Historic England

4 February 2021

Arrangements for Handling Heritage Applications Direction 2015

20-22 TALBOT STREET CHIPPING PR3 2QE Application No. 3/2020/0763

Title: **FLOOR PLANS AND SECTIONS PROPOSED LAYOUT**

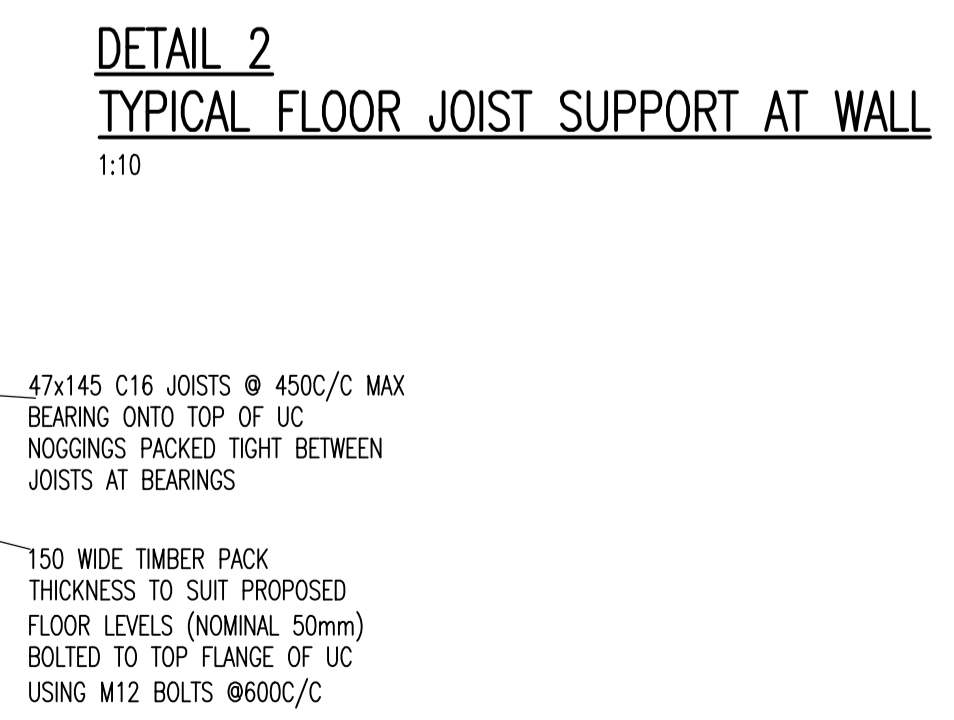
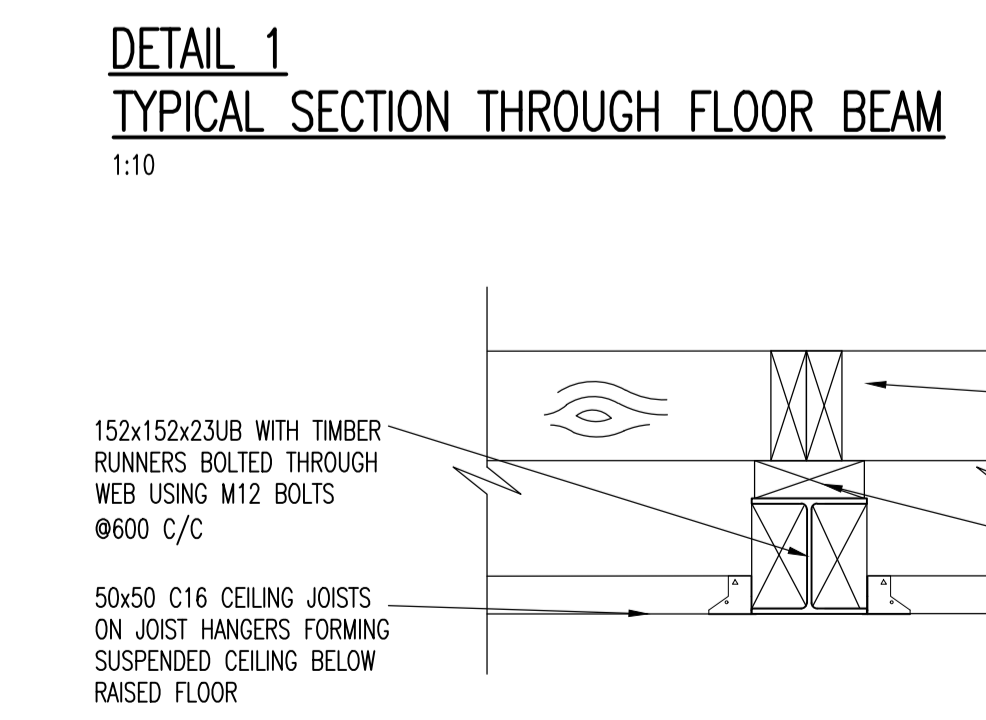
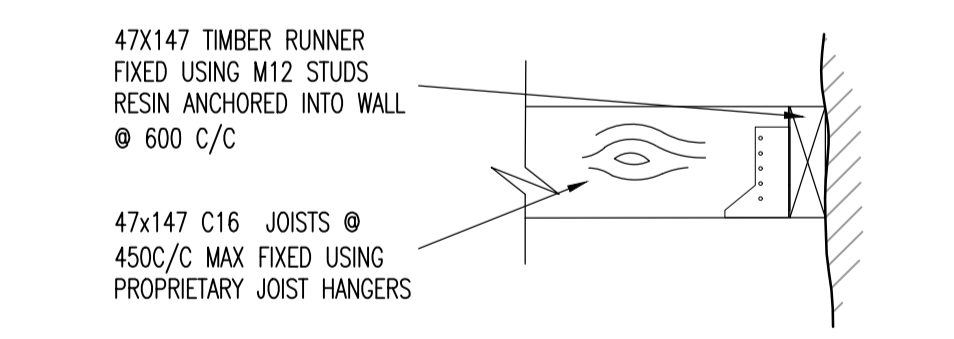
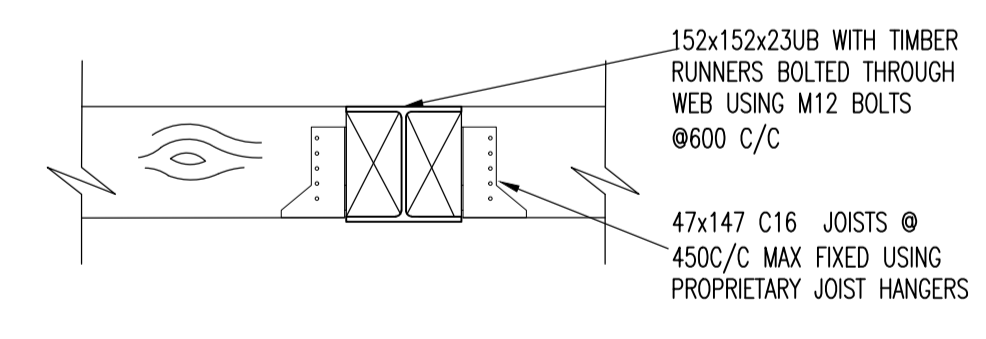
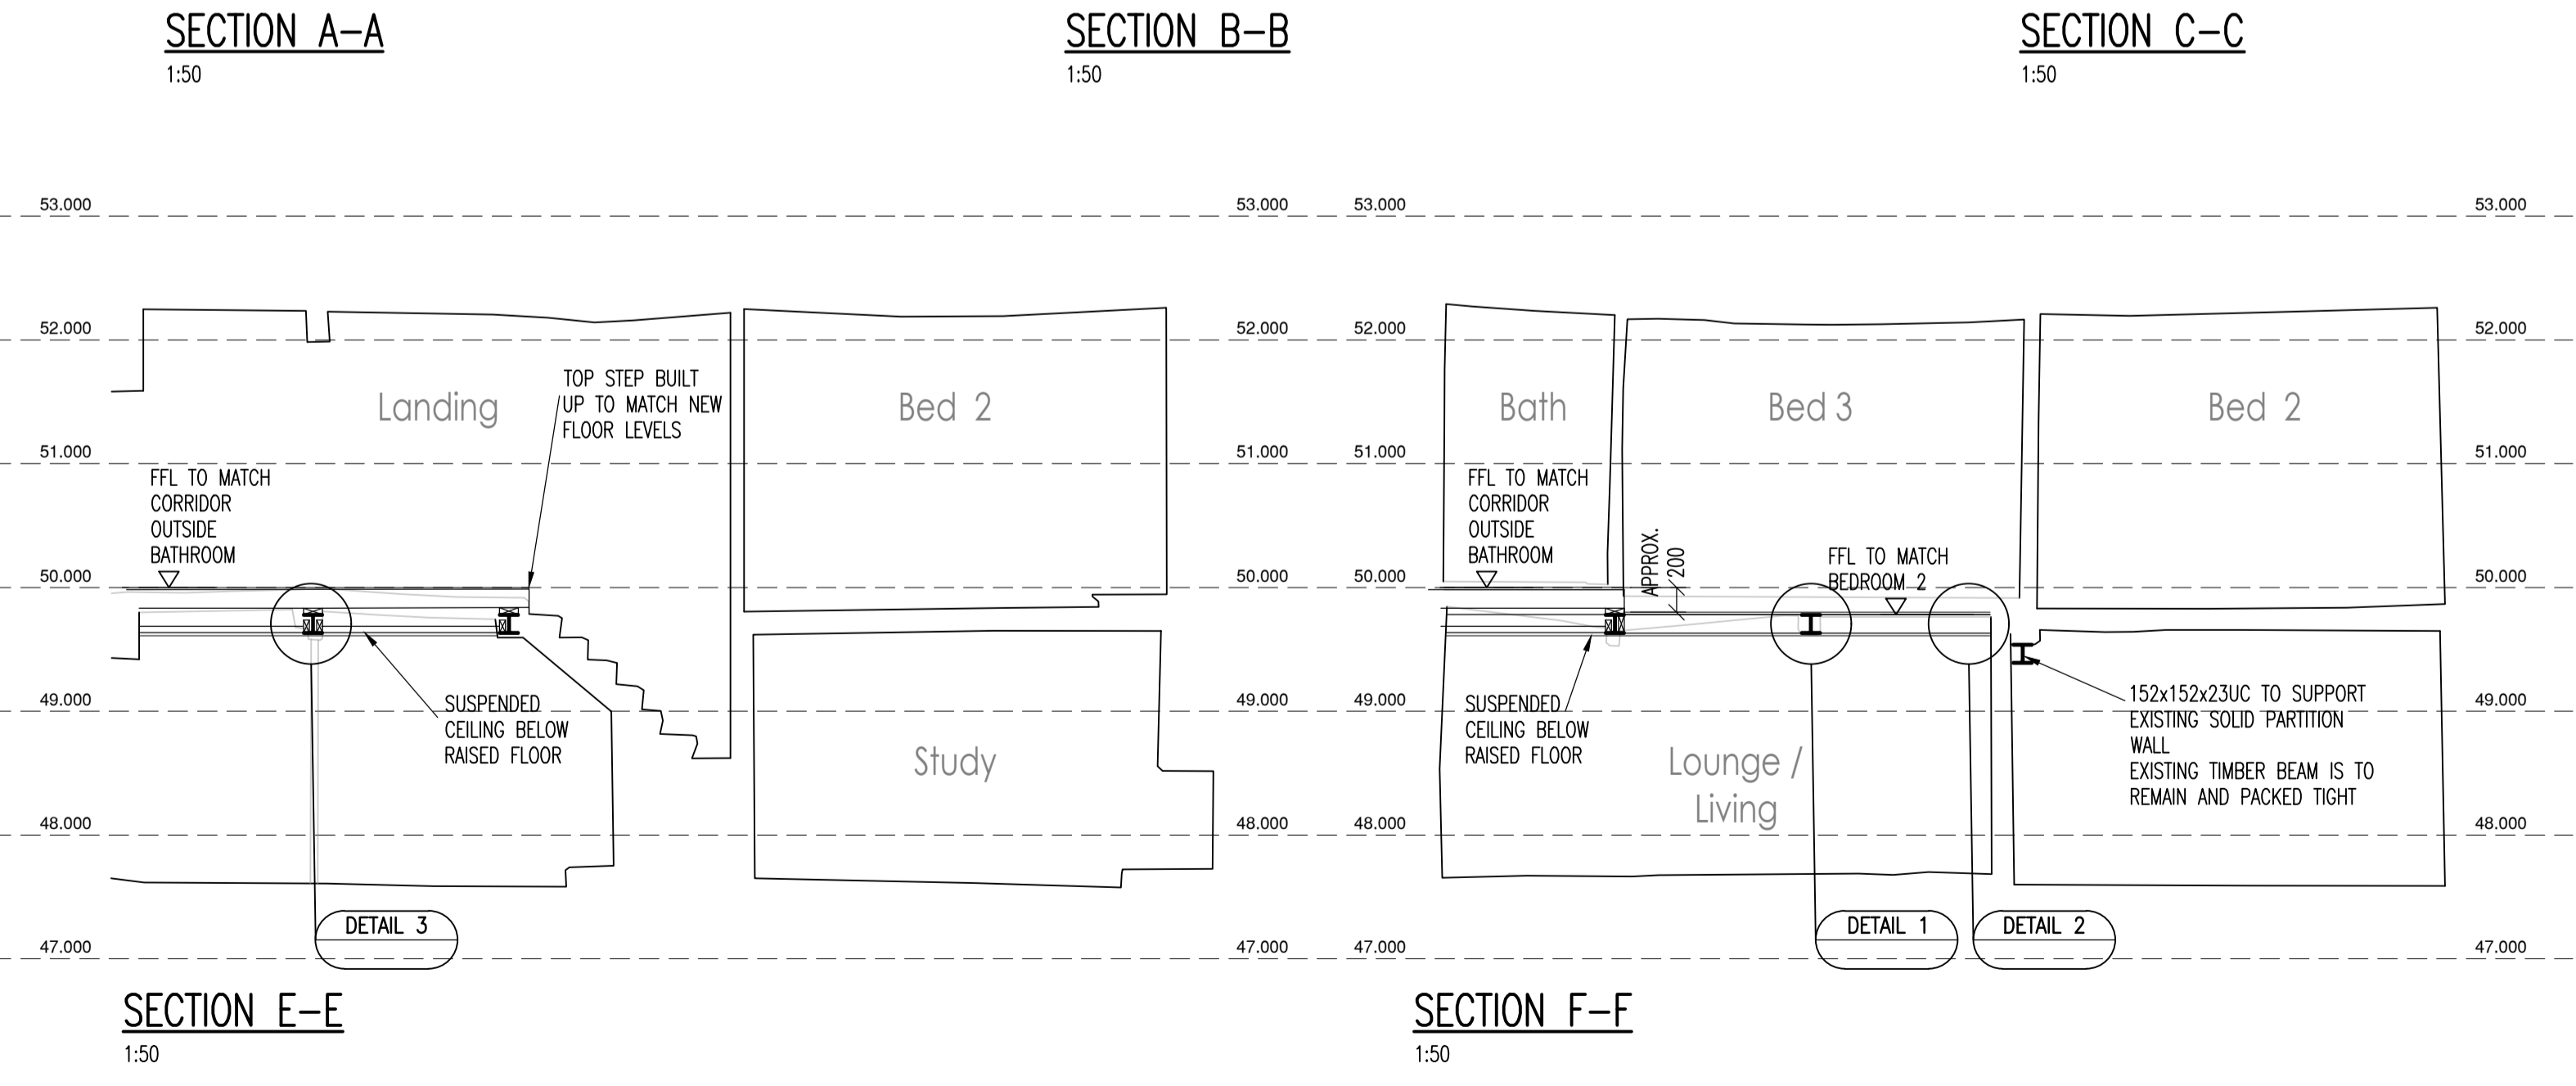
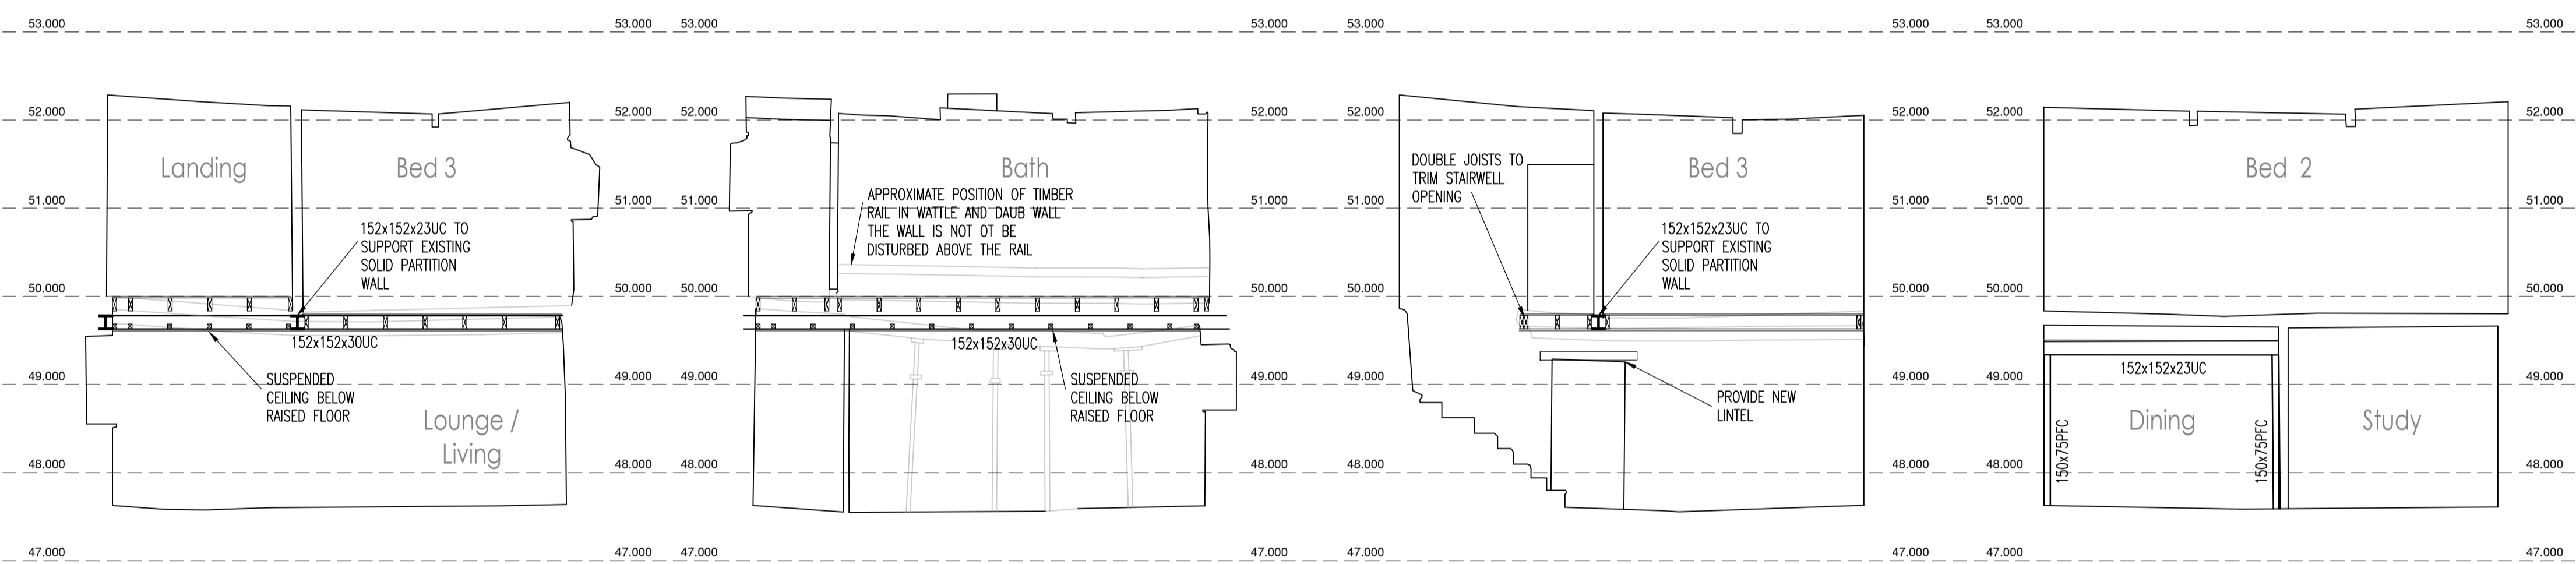
Beam 1, at the left hand end of the building on the submitted plans, has been overloaded, and as a result is suffering from excessive deflection and significant cracking.

It is proposed to rectify the issue through the complete replacement of the beam with steel and re-levelling of the floor. This would require much of the first floor structure to be removed, although much would be reinstated. It would also require the loss of the lower section of a surviving historic wattle and daub panel.

Beam 2, to the right of Beam 1 on plan, has been noted as showing some signs of diagonal cracking at mid-span, horizontal shakes and deflection, though not to the same extent as Beam 1.

Proposals look to remove and completely replace this beam with steel to ensure that it can carry the loads of partitions above and avoid further deterioration. Replacing Beam 2 would also allow for easier re-levelling of the first floor.

We do not object to the principle of repairing the beams identified. However, we do have concerns over the proposed method being put forward and the level of intervention the works would require to replace Beams 1 and 2.

The beams and first floor level floor structure are potentially part of the original construction and are therefore significant elements of historic fabric dating from 1668. We recommend that less invasive options be considered such as installing steels above the timber beams, taking the weight of the partitions and rendering them structurally redundant. The beams could then be retained in-situ by hangers from the new steels above (as suggested in Section 5.0 (2) of the Structural Report). Along with consideration of other options, we recommend that further analysis of the existing fabric is undertaken to establish its age and significance. This echoes advice we provided at pre-application stage.

Beam 3, within the Dining Room to the right hand end of the building on plan, has suffered a large crack, though it is unclear whether this is historic or live.

Previous attempts to support the beam are evident in the wedges installed below, cantilevering out from the adjacent partition wall to add support to the beam above. These have suffered rotation and are no longer providing support.

Proposals are to install new steel below Beam 3 instead of the supporting wedges. This will have a limited impact on the surrounding fabric where new bearing will need to be provided for the steel beam.

We are content with the proposal to support Beam 3.
